Scale 1" = 20'  
Contour Interval: 1'

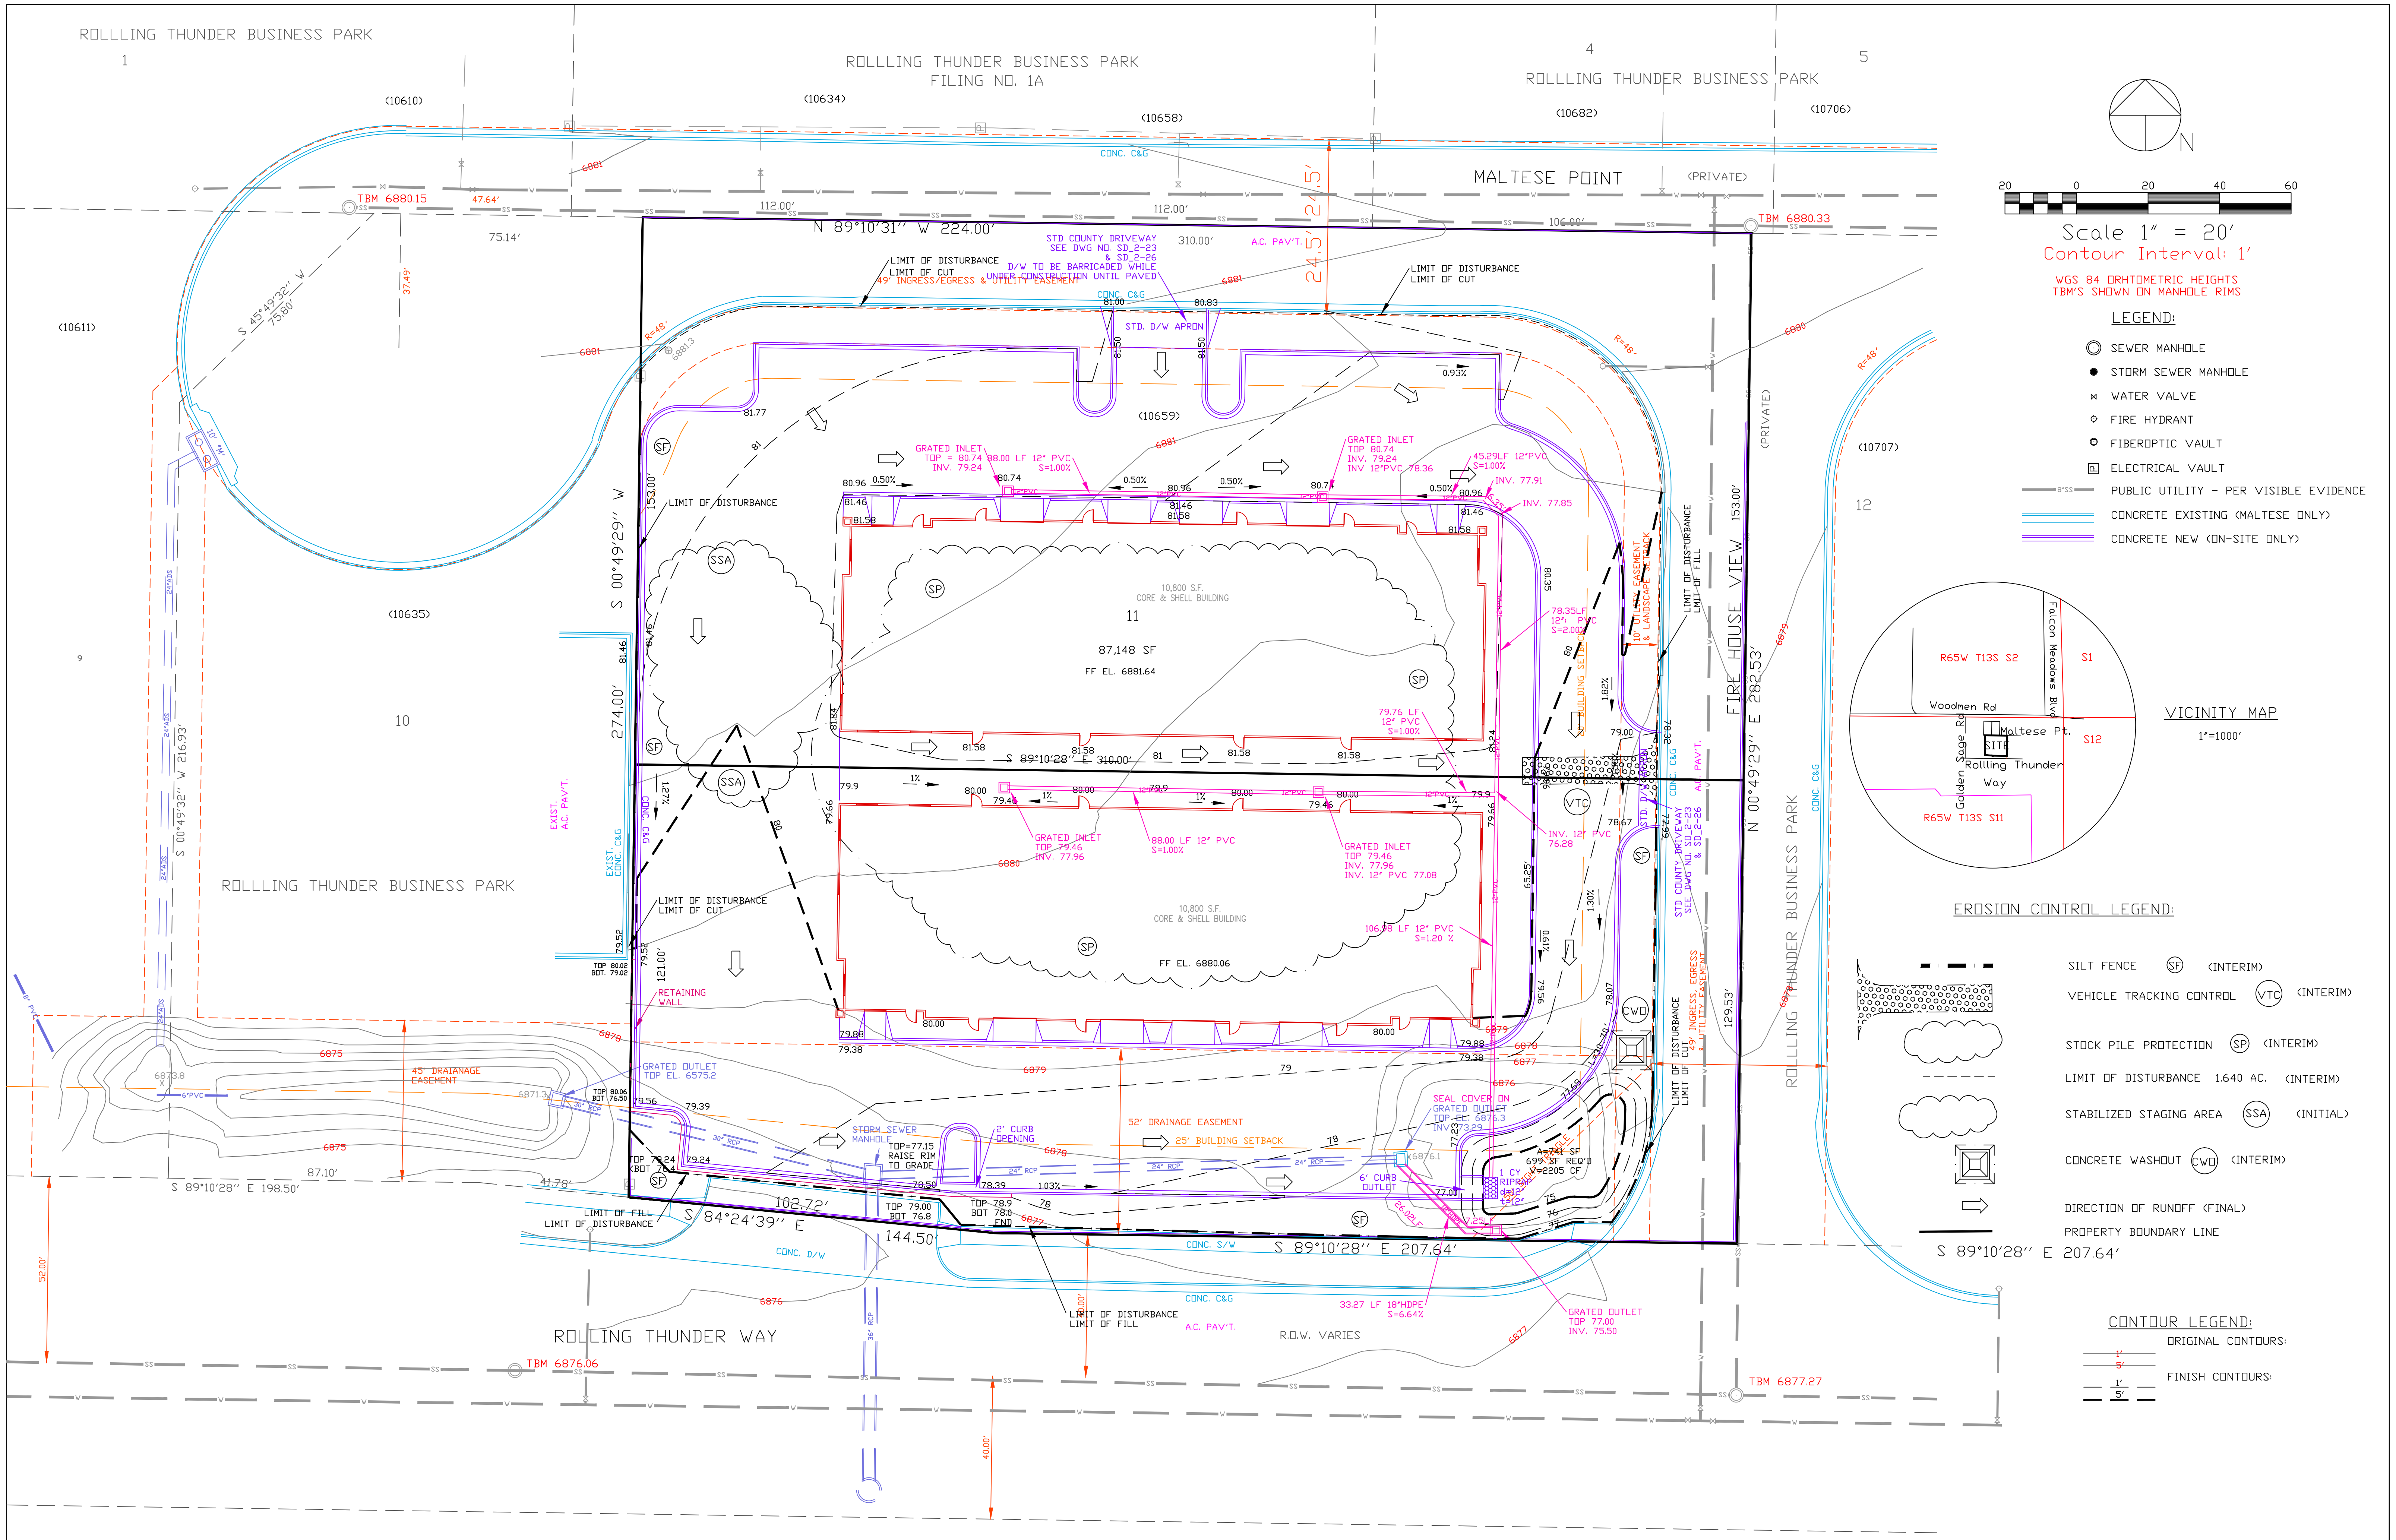
provide location and details for spill curb and carry curb as discussed during our April 26 meeting.

This area should be cut. I am still unable to identify the cut/fill areas. Shading the cut/fill areas may work best, visually.

Please add Silt Fence line from V3

doesn't match UD-BMP calcs

provide detail and dimensions of inlet, riprap rundown, and 12\"/>

713SF in accordance with Drainage Report, -1100SF according to the UD-BMP for PLD

During our April 26 meeting we discussed adding a cross pan here to keep all SW onsite and directed towards the SFB.

You agreed to change these to "initial/interim" during our meeting on April 26
